FINAL DRAINAGE REPORT FOR GLENEAGLE GOLF COURSE RESIDENTIAL INFILL DEVELOPMENT FILING NO. 2

February 12, 2019
Project Number 03524

VR-18-018

FINAL DRAINAGE REPORT
GLENEAGLE GOLF COURSE RESIDENTIAL INFILL DEVELOPMENT
FILING No. 2

A REPLAT OF TRACT G, GLENEAGLE GOLF COURSE RESIDENTIAL INFILL DEVELOPMENT, IN THE SOUTHWEST QUARTER OF THE NORTHWEST QUARTER AND THE NORTHWEST QUARTER OF THE SOUTHWEST QUARTER OF SECTION 6, T12S, R66W, 6th P.M. EL PASO COUNTY, COLORADO

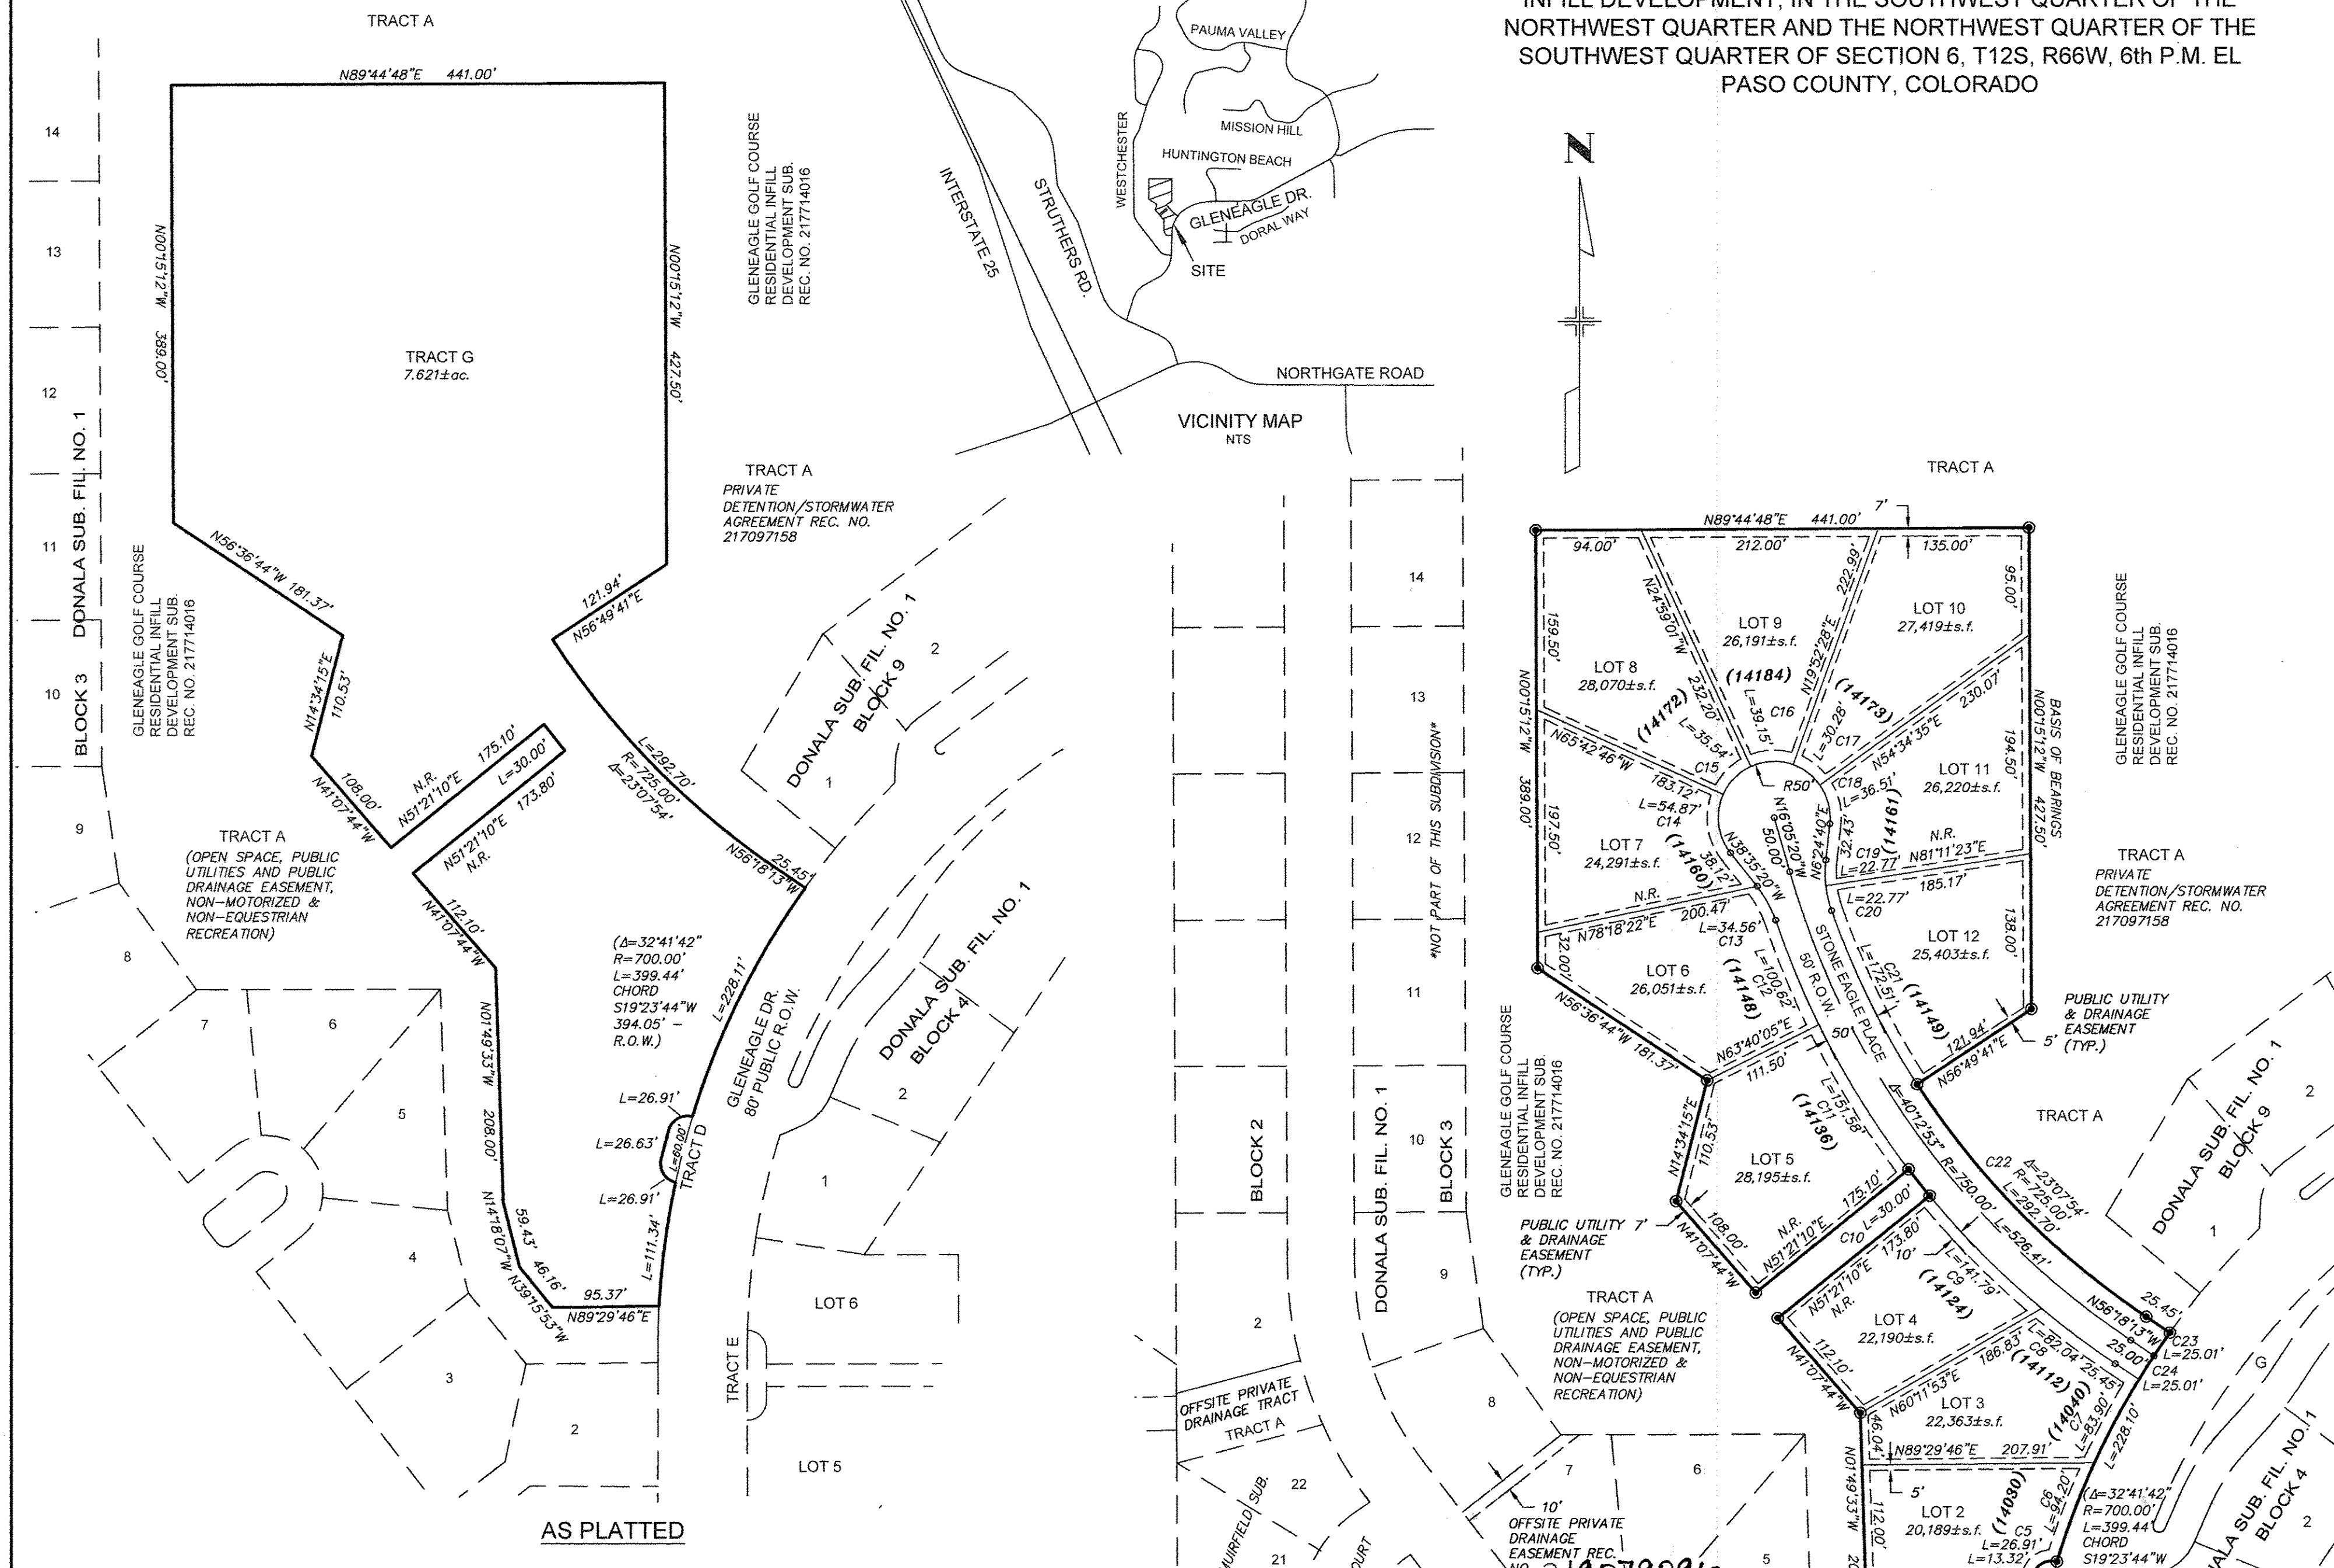
Please call out the arrangement for Lot 7 to have the Private 24 inch HDPE Pipe. Is there a Drainage easement granted. Identify the owner and maintainer of the easement.

Clarify who maintains the Extended Detention Basin, All the Swales shown in the tracts the private storm sewer etc. Call out the entity responsible for ownership and maintenance. Also provide this on the Plat.

Clarify in the text, that the Roadway and Utility Easement Book 2767 Page 809 will be used as a Public Drainage Easement for the 30 inch storm sewer. Clarify that El Paso County has access to the storm sewer with this easement.
